CITY OF ALBUQUERQUE

June 20, 2024

RE: Martinez Retail Center
1021 Old Coors SW
Grading Plan
Engineer's Stamp Date: 6/11/2024
Hydrology File: L11D071

SHEET NO: C-1

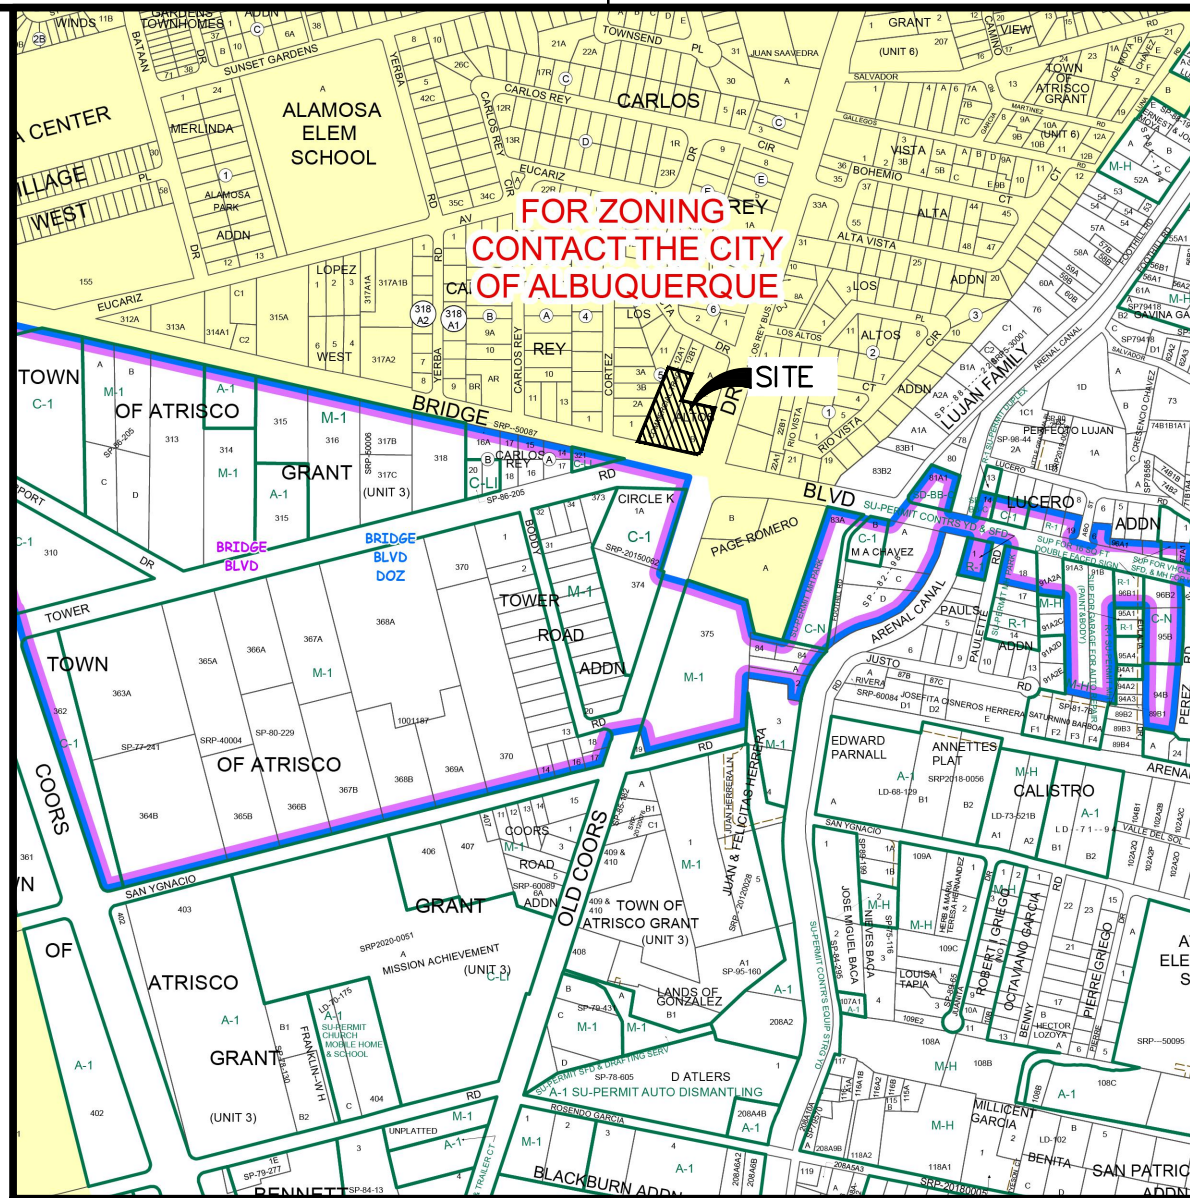
1. Please provide all drainage calculations required by the DPM. Be sure to include the existing and developed conditions for flows and volumes required.
2. There appears to be a total of 8 Storm Water Quality Ponds shown on the plan. Two of the ponds are labeled as Pond 5. Please correct pond numbering and include the missing pond data in the table.
